From: Andrew Wood
Sent: 26 February 2019 17:42
To: Planning.Responses
Subject: FW: Planning Application FG/220/18/PL : Land adjacent to Elm Lodge, Tamarisk Way, Ferring, West Sussex BN12 5ER

From: Katherine Jenkins [REDACTED]
Sent: 22 February 2019 12:27
To: Laura Gibbons
Cc: Andrew Wood
Subject: Re: Planning Application FG/220/18/PL : Land adjacent to Elm Lodge, Tamarisk Way, Ferring, West Sussex BN12 5ER

In order for me to remove my objection I am going to need some further information to be supplied:

PROPOSED SITE SECTION 1:100.

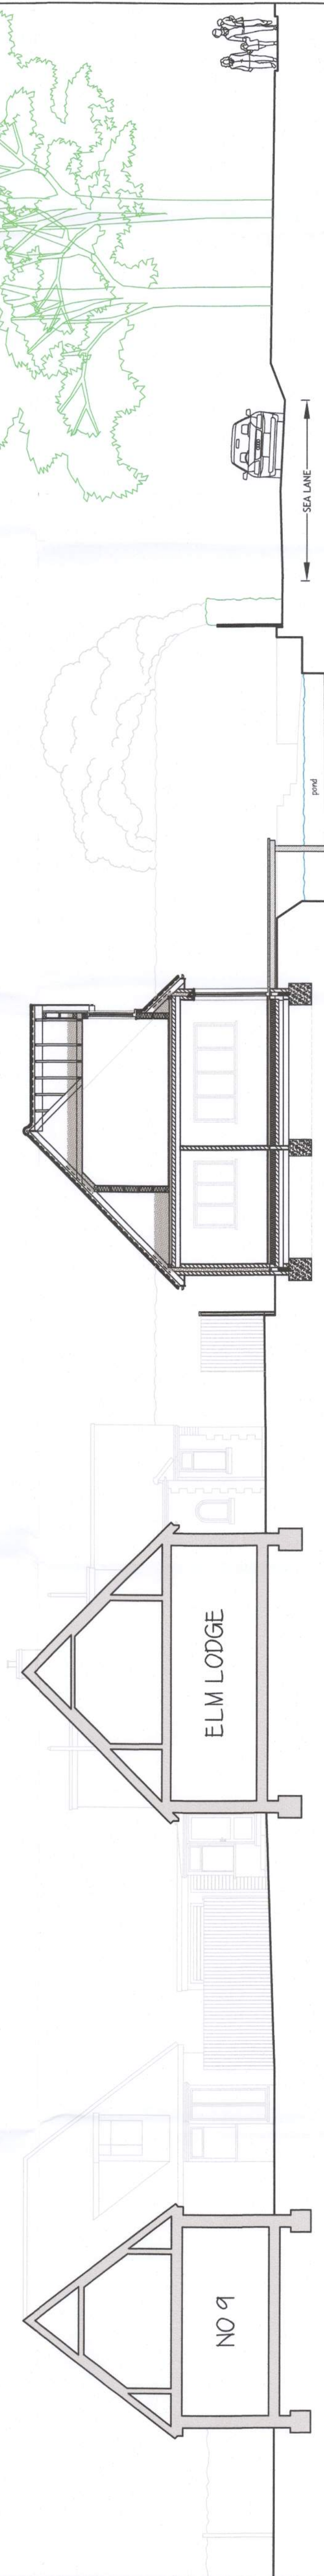
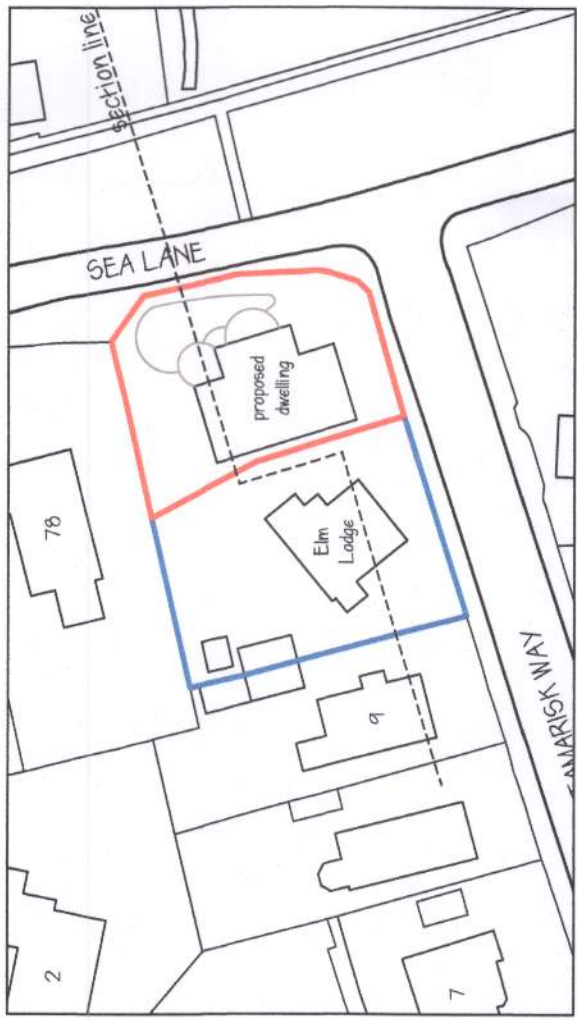
4. It also needs to be demonstrated that the volume of pond to be infilled will be compensated for elsewhere. We will not be infilling the pond. The pond is to be retained as existing. The only part we are looking to change is the path to the west of the pond, which will have new turf added over the existing overgrown vegetation. This will not affect the volume of pond since there is no water in this area. We are happy for you to condition the application to ensure the pond is not infilled. In flood conditions the area that is currently used as a compost heap provides volume for water storage, this would be lost with your current proposals.

Regarding your point below that "In flood conditions the area that is currently used as a compost heap provides volume for water storage, this would be lost with your current proposals", there is no history of any flooding on the site, or water breaching the current edge of pond. We would be infilling this small area of land with soakaway crates, designed by specialists, to ensure it can still hold any excess water under the new turf covering.

EXISTING POND ACCESS
PLAN

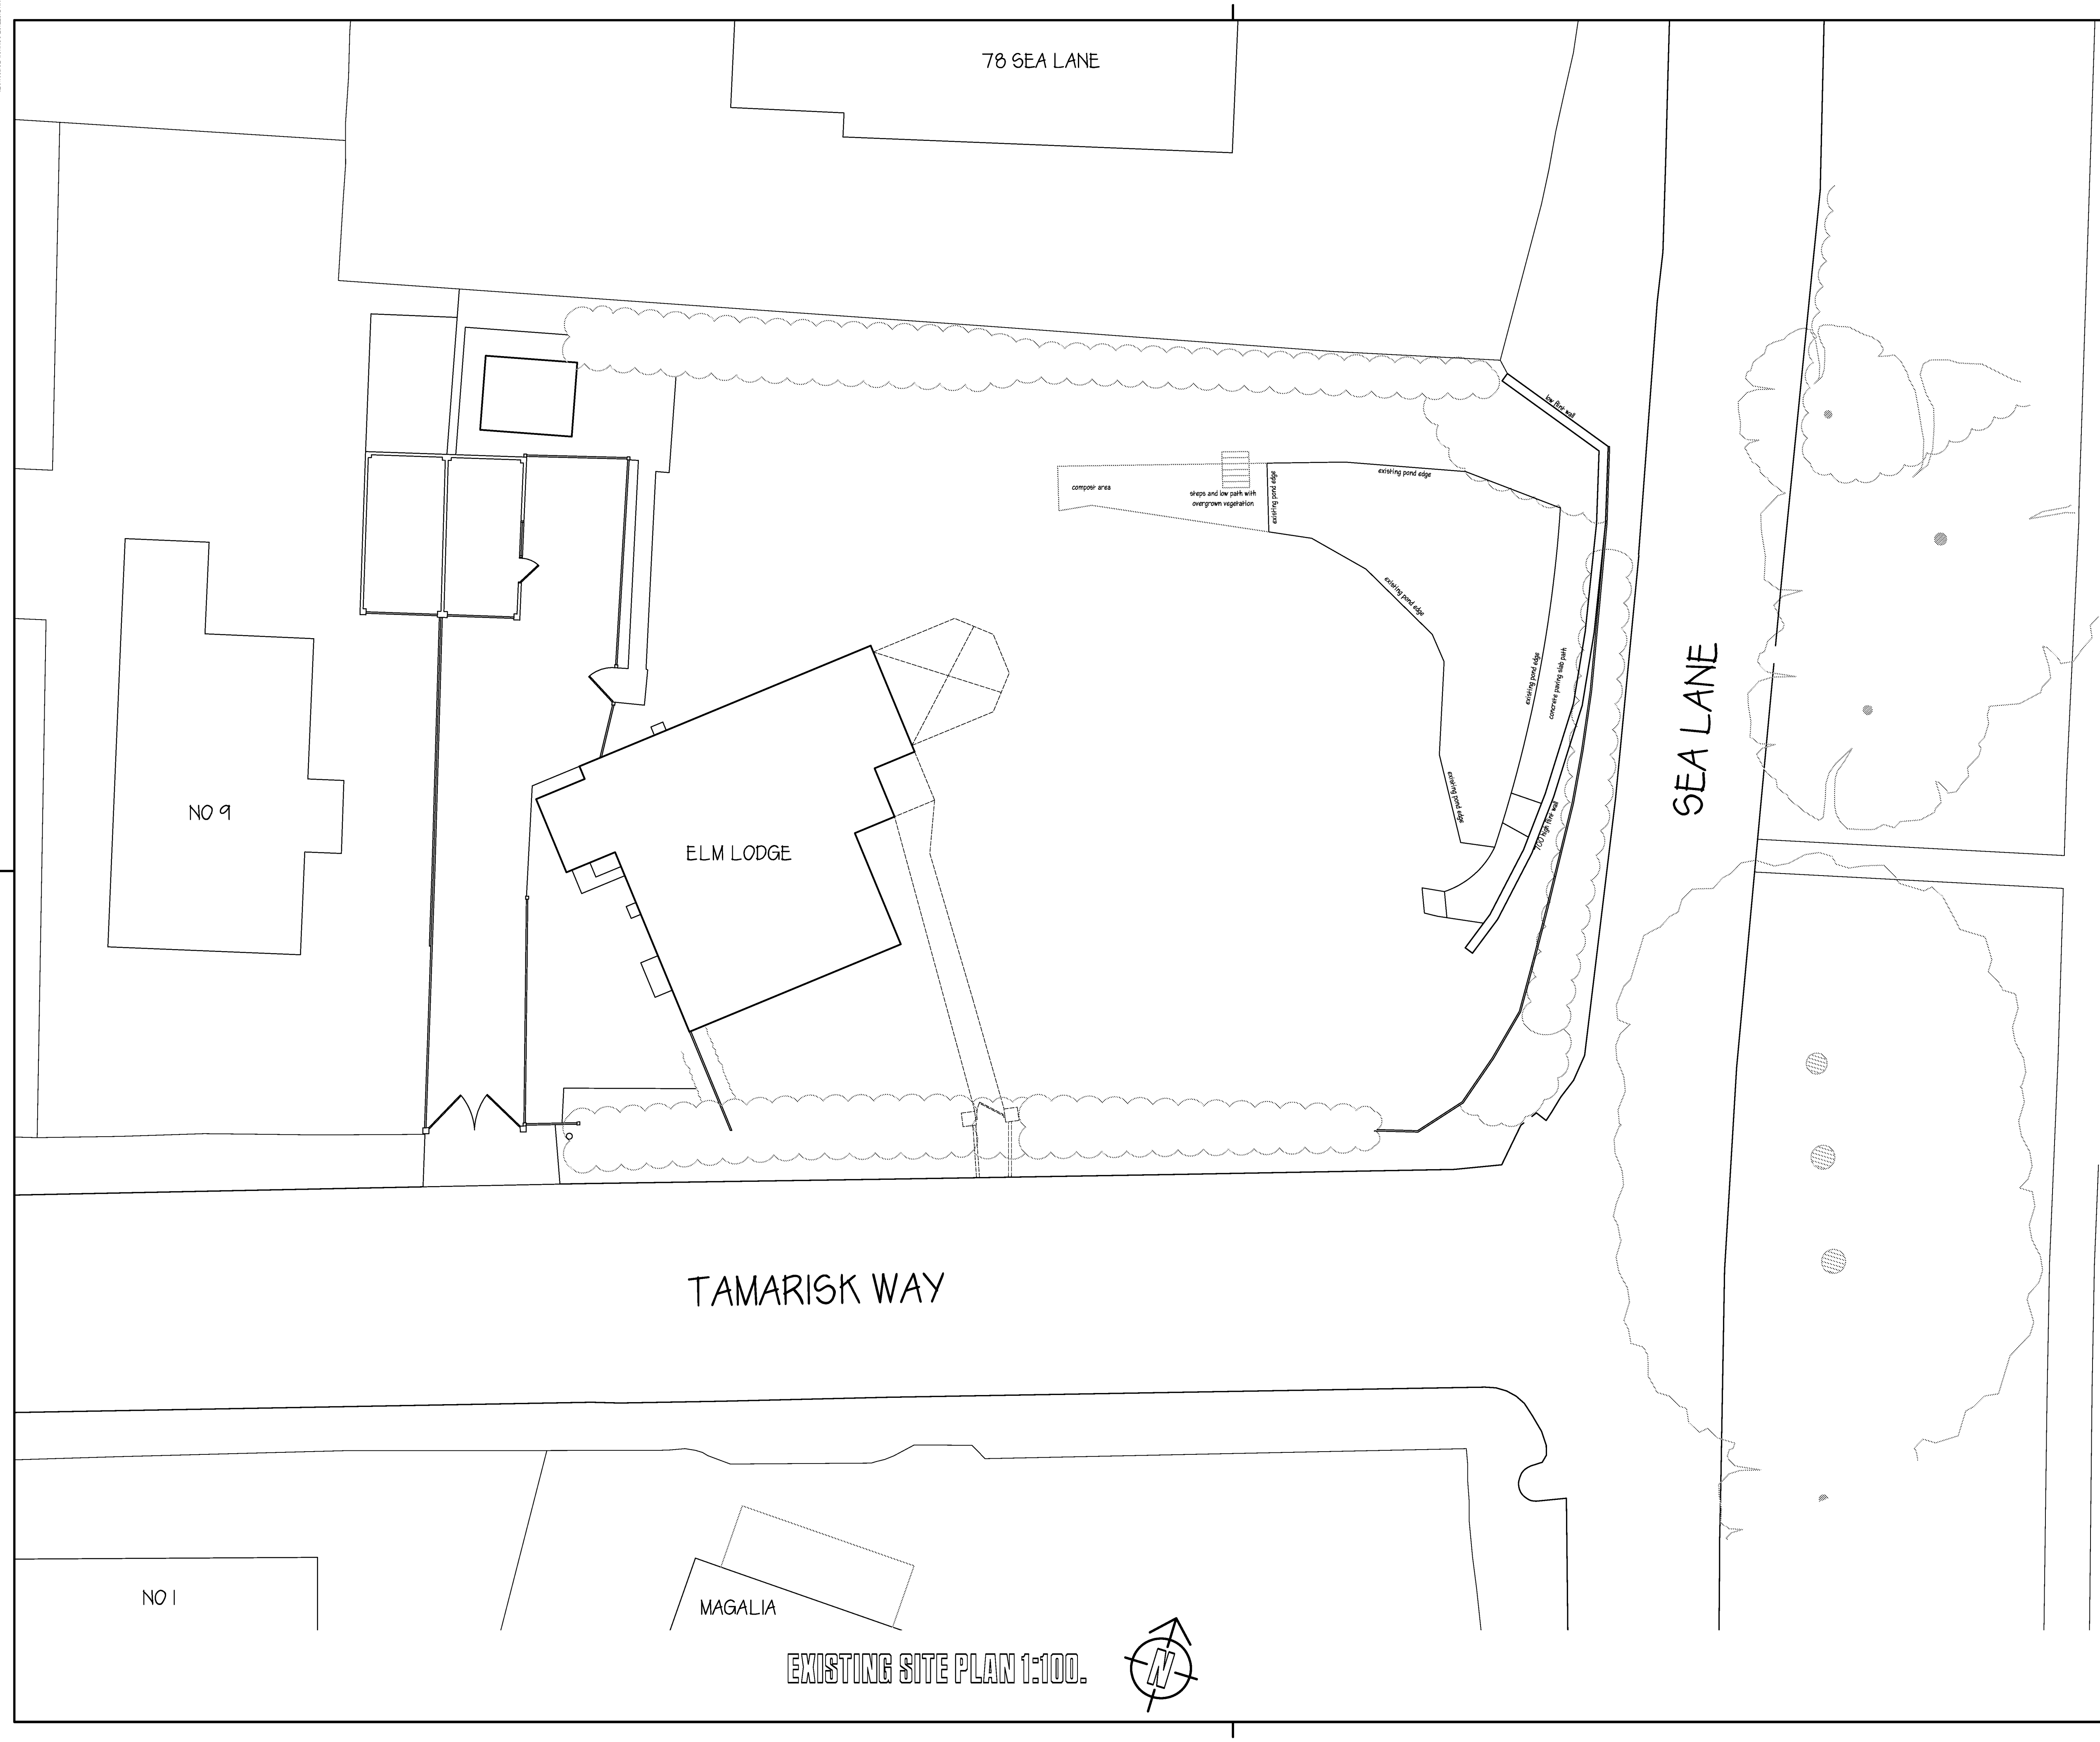
3. It is my belief that there is no way to get to the northern and western portions of the pond without tracking through the pond itself. This would mean that maintenance would have to be completed in the summer by the landowner when water levels are lower. This would then be within nesting bird season. I would much prefer an access to be provided around the pond. I note that you state the 1m wide path to the east could take plant but this plant would not be big enough. As explained above, we as landowners can continue to access the pond from all sides, with 3m to the West, North and South East. We cannot understand what plant would ever be required (given no plant has ever needed to access the pond before, and any plant necessary for carrying out works to the pond can have full access from all sides as part of the building works) that would ever be larger than a small digger, which can easily be maneuvered up the 1m side access to the west of site and around the rear. You are going to need a large digger to access the pond and clear it of vegetation and silt. The size of machine is dictated by the depths that excavation need to be carried out to, the size of plant that can fit along a 1m path would not be sufficient to carry out the excavation required. Ongoing maintenance will be required after construction is complete, this is when the proposed site layout in my opinion would prevent this work.

These show the existing pond to be retained in its entirety, with 3m access provided should Arun District Council ever need to access our property to maintain the pond. We hope these now alleviate your concerns regarding potential future access. We also note that the path to the east of the pond is also over 1m wide, which can currently comfortably accommodate a 1.5 ton digger to carry out any works. Given that there are multiple points of entry along the edge of the pond, any further work can be carried out from within the pond.
